RE: Comment Response for Front Range-Midway Solar Project, LLC Application for a Wind/Solar Energy Generation Overlay (WSEO), Submittal #1,

Front Range-Midway Solar Project, LLC (Project Company) is pleased to submit the revised sections of the Front Range-Midway Solar Project (Project) application for a Wind/Solar Energy Generation Overlay (WSEO), submittal #1. The revisions to this application address the review comments provided by the El Paso County (EPC) Planning & Community Development on November 27, 2017. All comments provided in the letter and the Project's response or a reference to Project's response within the WSEO application are listed below.

WIND/SOLAR ENERGY GENERATION OVERLAY (WSE-O) PLAN (WSEO-17-001)

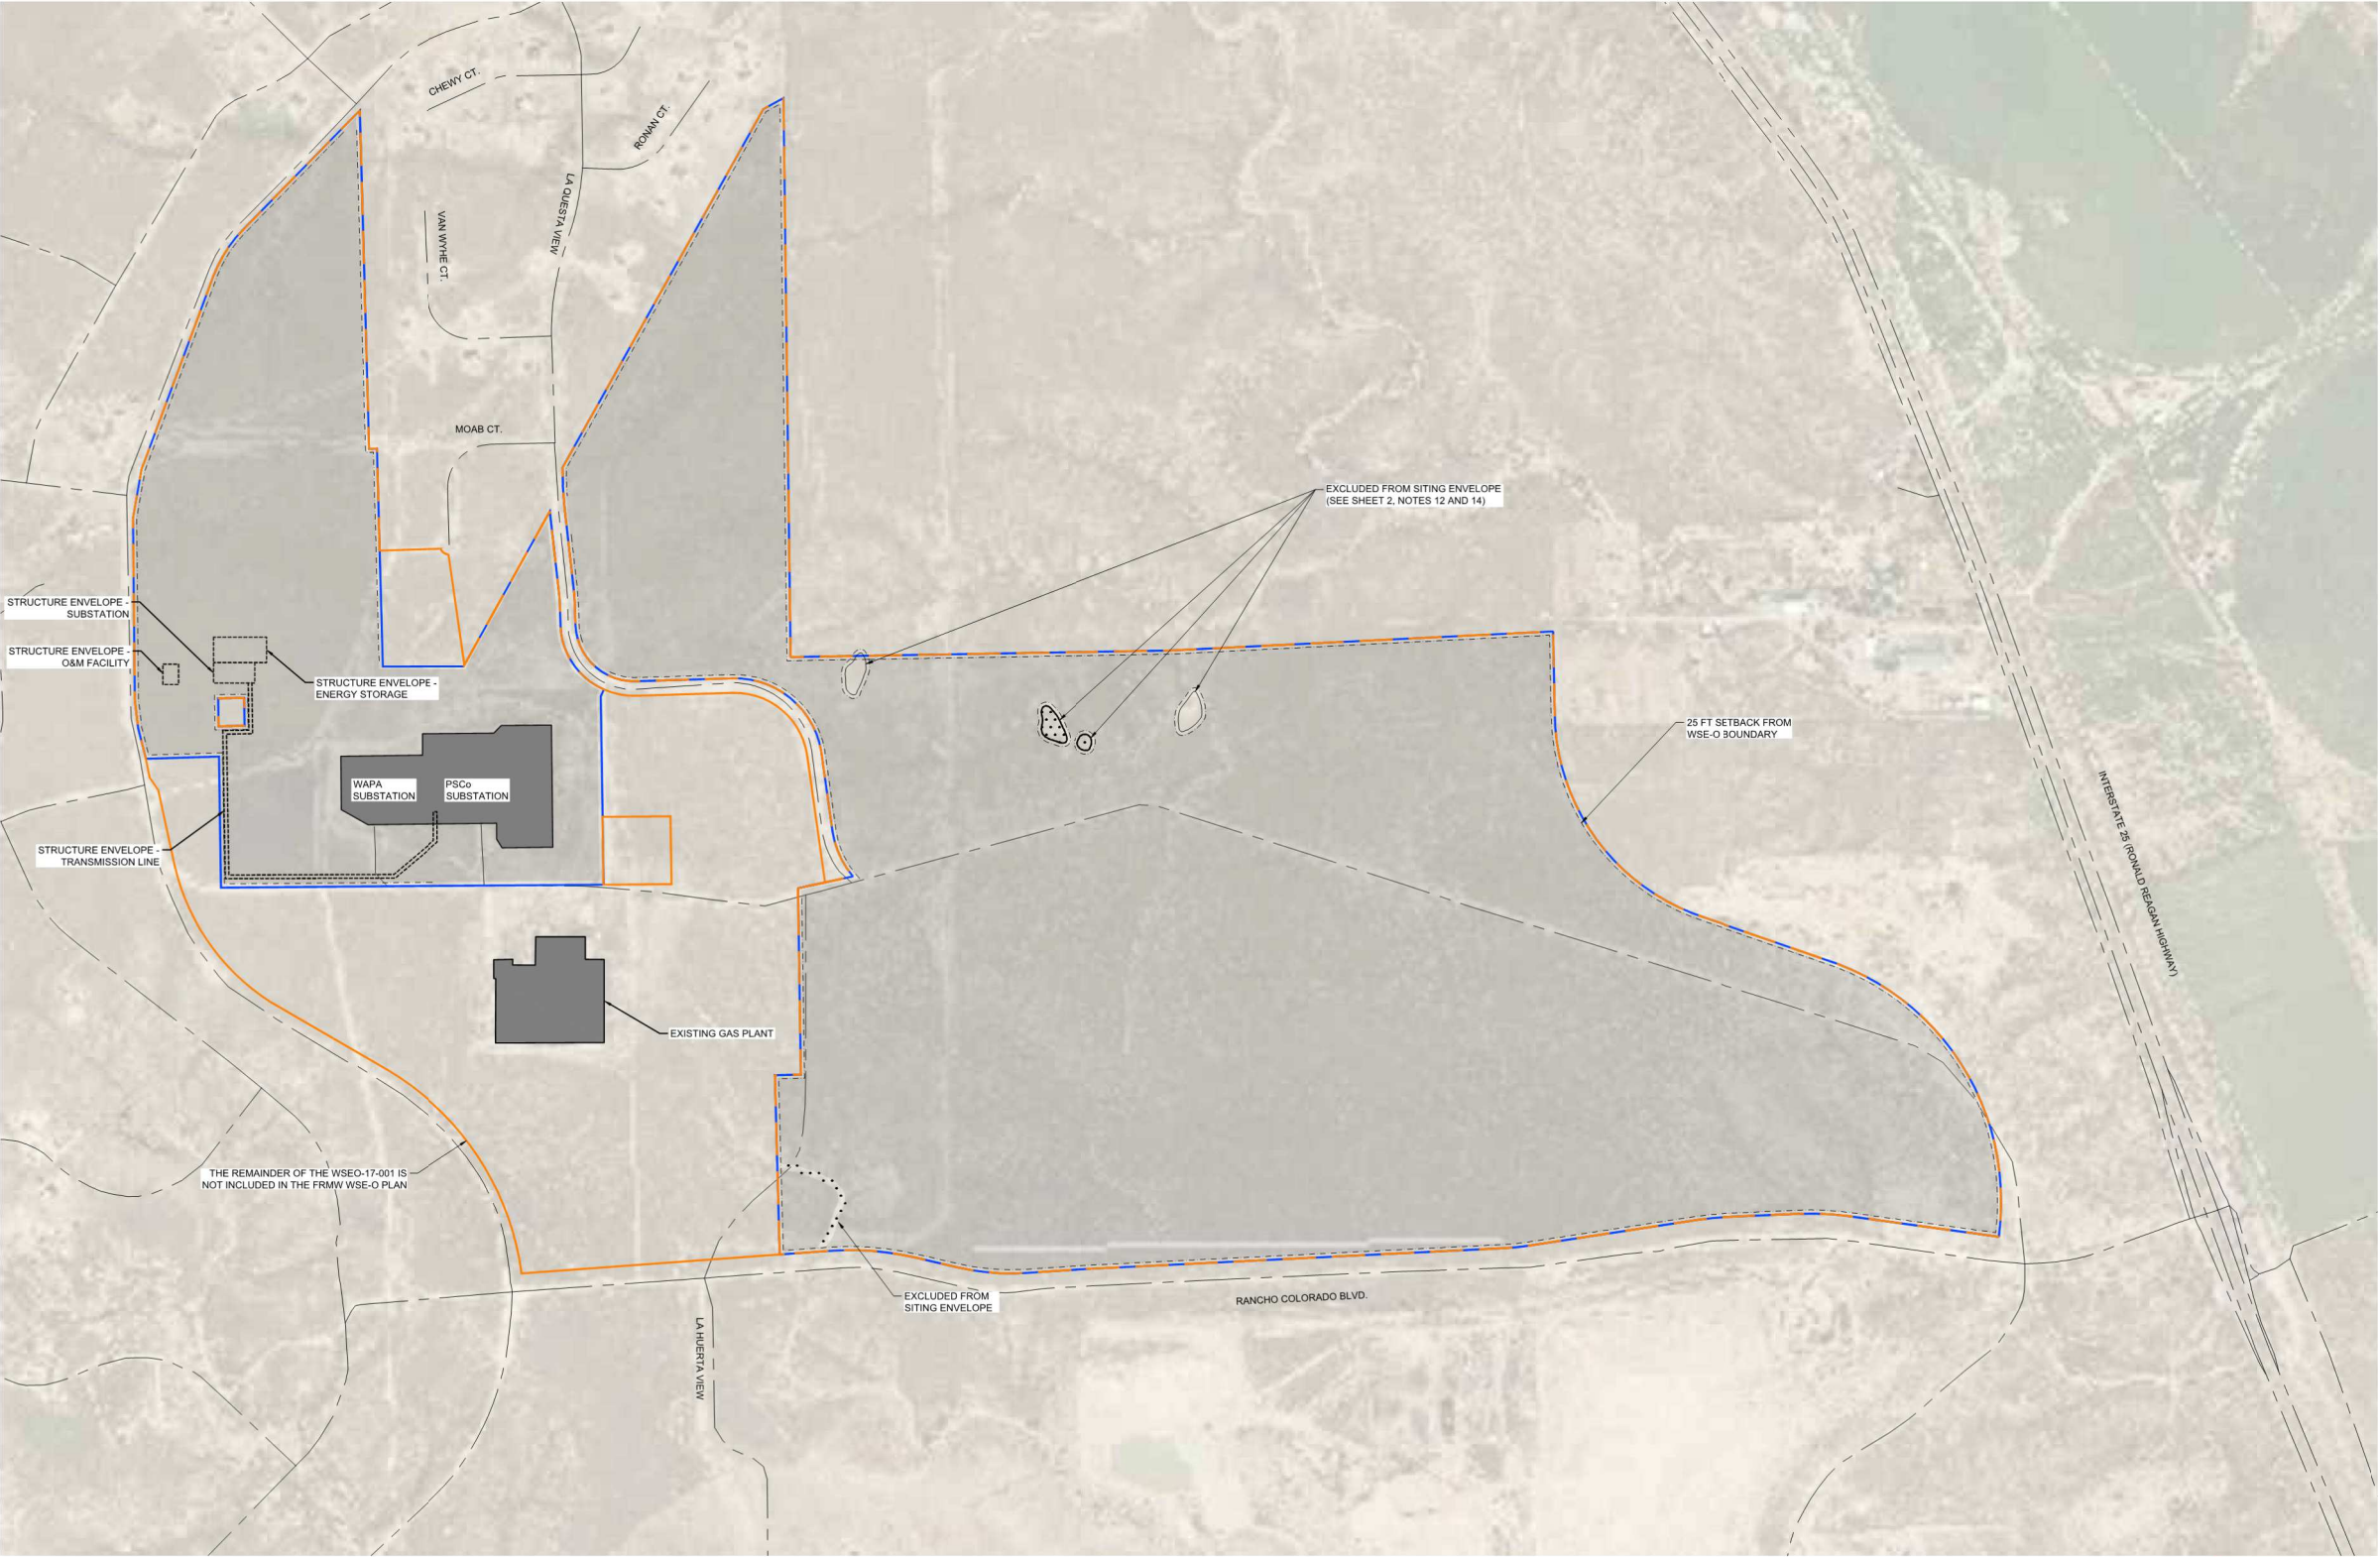
1. Two class III cultural sites (prehistoric) were identified within the project boundary area. [lithic reduction locale, surface assemblage is fragmented- moderate potential for buried cultural materials] The State Historic Preservation Officer (SHPO) and [Front Range-]Midway Solar have agreed to preserve the sites by avoidance; however the area is shown to have solar arrays.

2. The sites (5EP7625 and 5EP7632) identified in the September 2016 final environmental assessment are located at the northern portion of the property east of La Questa as depicted above. A letter from the SHPO has been provided. If avoidance cannot be adhered to further excavation would be necessary, please provide further documentation.

Response: Preliminary design has been updated to avoid the potential archeological sites identified in the Class III Cultural Resources Inventory and recommended for avoidance. Please see updated Site Plan (Attachment M), which depicts avoidance of archeological sites. All other Attachments show avoidance of these sites, including the WSEO Plan.
